**RE: ALDI WAREHOUSE PROJECT AND REVISED SUBDIVISION LAYOUT  
SUBMISSION (MP 10\_0042)  
RESPONSE TO SUBMISSIONS**

*Table 1.1 Response to Authority and Community Submissions*

Figure 8: Access Arrangements

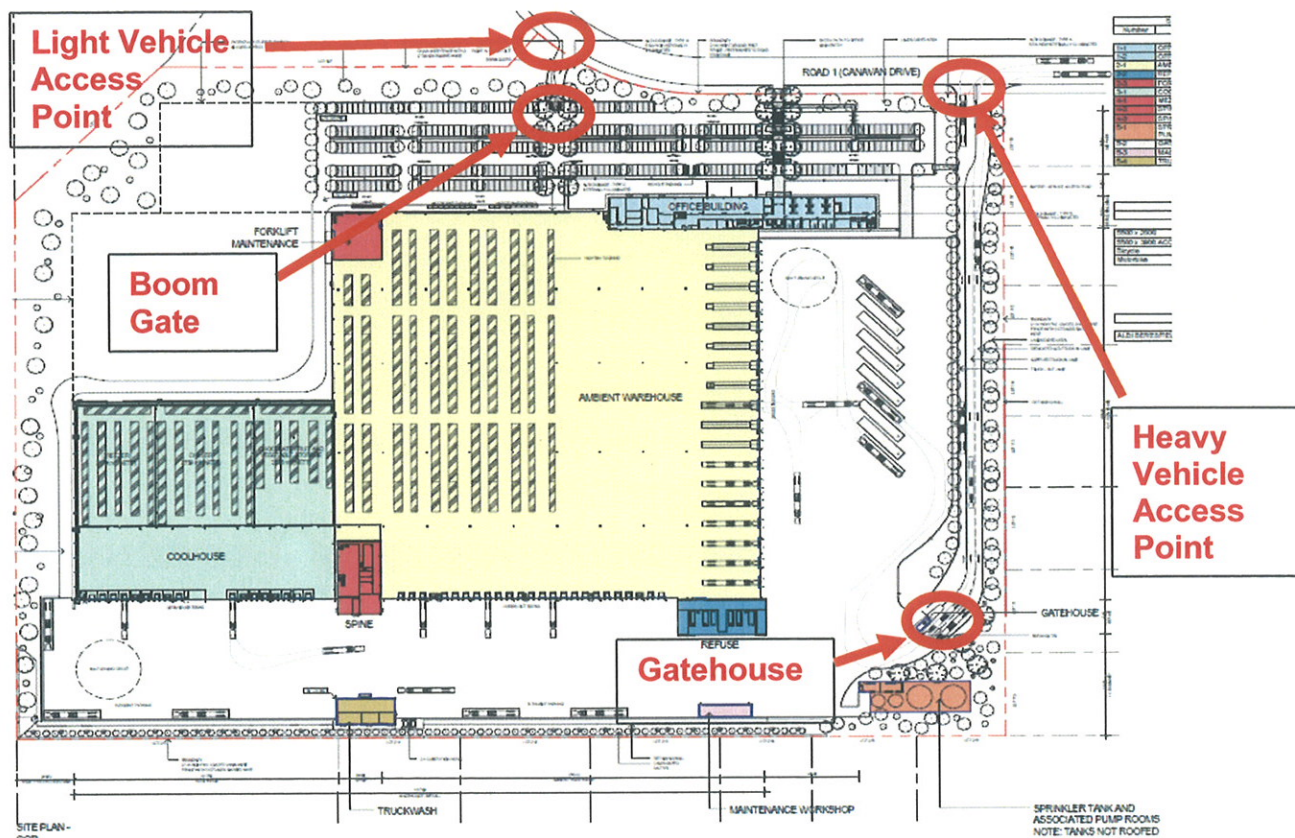
- The queue lengths for traffic in front of the boom gates is to be investigated to ensure that queues don't overflow onto the roadway during the peak for both the truck entry and the standard vehicle entry

<p>queues don't overflow onto the roadway during the peak for both the truck entry and the standard vehicle entry.</p>	<p>queuing for cars entering the car park is discussed in paragraph 3.21 of their previous report submitted with the Development Application. A boom gate will control access to and from the car park. Queuing for some five to six vehicles will be provided between Road 1 and the control point, in accordance with the Australian Standard for Parking Facilities (Part 1: Off-street car parking), AS 2890.1:2004 for a car park of the size and type proposed.</p> <p>Truck queuing is discussed in paragraph 3.17 of their previous report submitted with the Development Application. There is queuing space to accommodate some 10 b-doubles or 14 semi-trailers between Canavan drive and the gate house. By comparison, the proposed queuing area for trucks at Beresfield, within the site, prior to reaching the gate house and security point, is several times longer than at ALDI's existing distribution centres at Minchinbury and Prestons, which function appropriately.</p>
